March 1, 2021

**RE: DUTCH BROTHERS COFFEE  
3615 NM 528  
TRAFFIC CIRCULATION LAYOUT**

February 16, 2021

Re: **Dutch Brothers Coffee**  
**3615 NM 528**  
**Traffic Circulation Layout**  
Architect's Stamp date 2/09/2021 (A14D019)  
Via email lnoriega@tierrawestllc.com

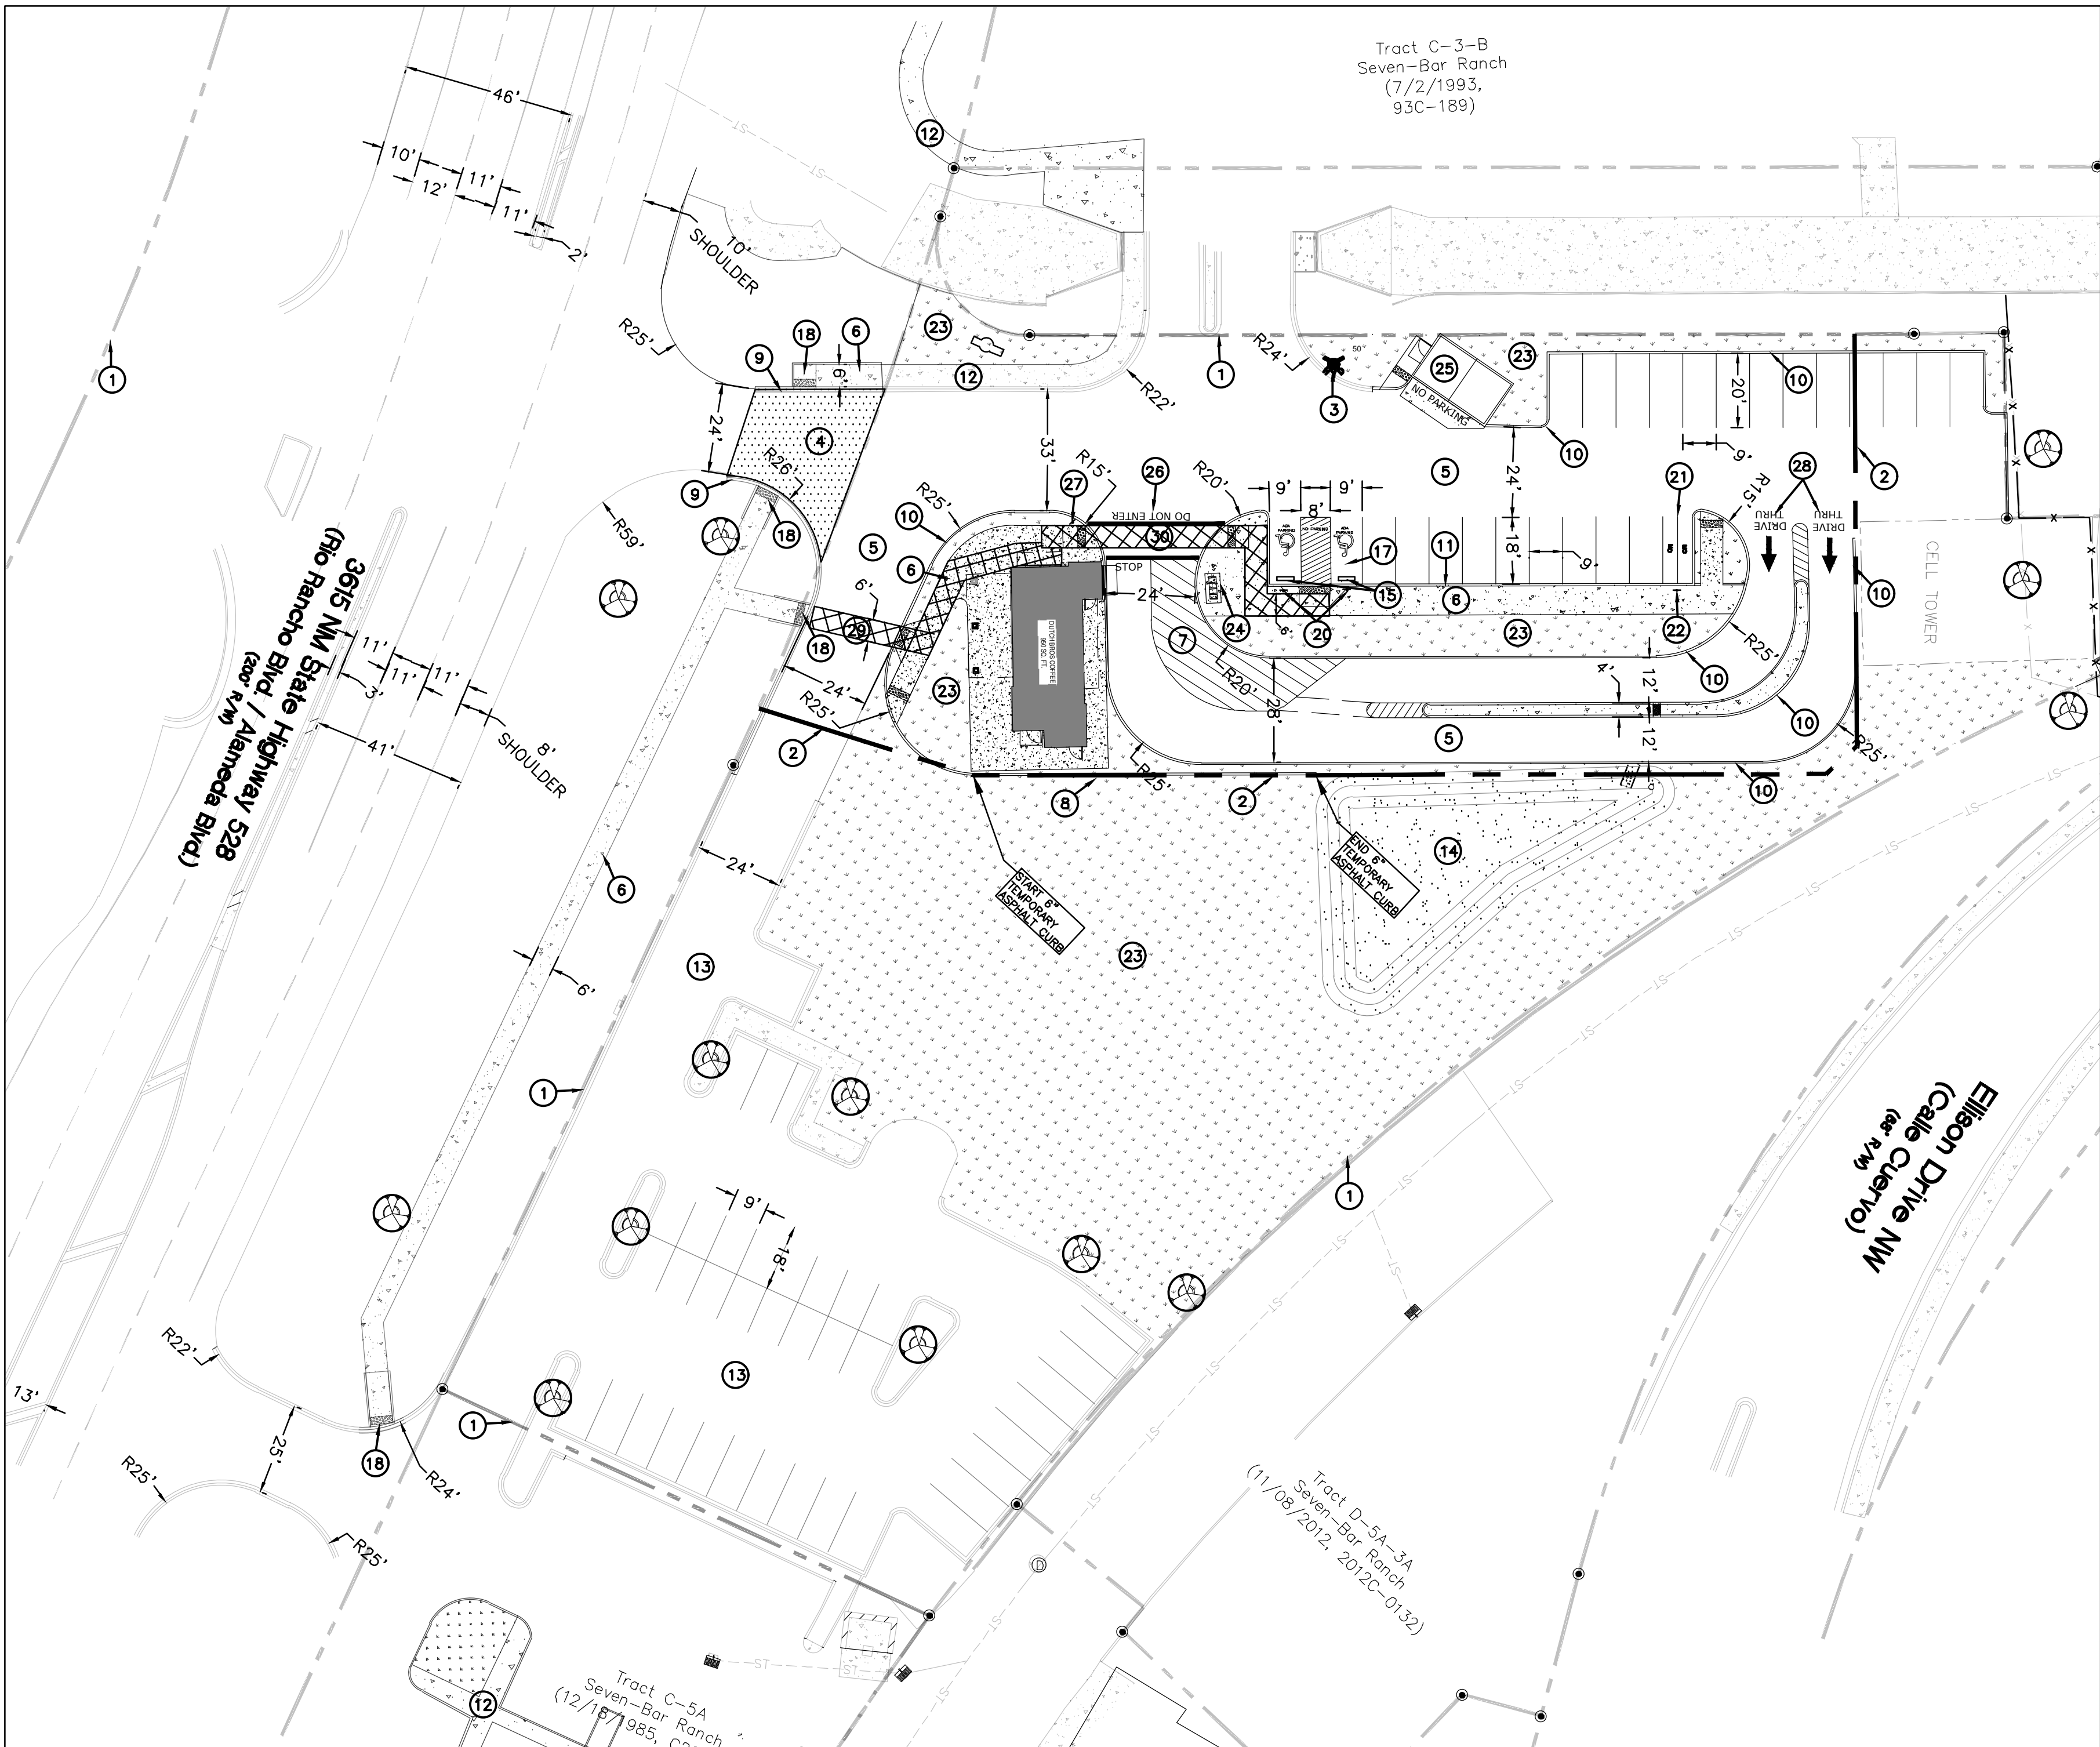
1. Provide a Traffic Scoping Form or approved Traffic Impact Study for the development.
2. Provide shared access agreement for the adjacent property and share use agreement for the driveway on NM 528.
3. Fire and emergency access: Provision for access by fire and emergency vehicles needs to be in accordance with the Albuquerque Fire Plan Checking Division. Provide approval from the Fire Marshall.
4. Suggested sidewalk and ramp alignment on attached drawing.

1. Provide a Traffic Scoping Form or approved Traffic Impact Study for the development.  
**Response: See supplemental document page 1-2**
2. Provide shared access agreement for the adjacent property and share use agreement for the driveway on NM 528.  
**Response: See supplemental document page 5-6, plat documents the existing access easements (Easement # 1 and 13).**
3. Fire and emergency access: Provision for access by fire and emergency vehicles needs to be in accordance with the Albuquerque Fire Plan Checking Division. Provide approval from the Fire Marshall.  
**Response: See supplemental document page 7, Fire 1 approved on 9/22/2020**
4. Suggested sidewalk and ramp alignment on attached drawing.  
**Response: See updated TCL plan sheet C1**
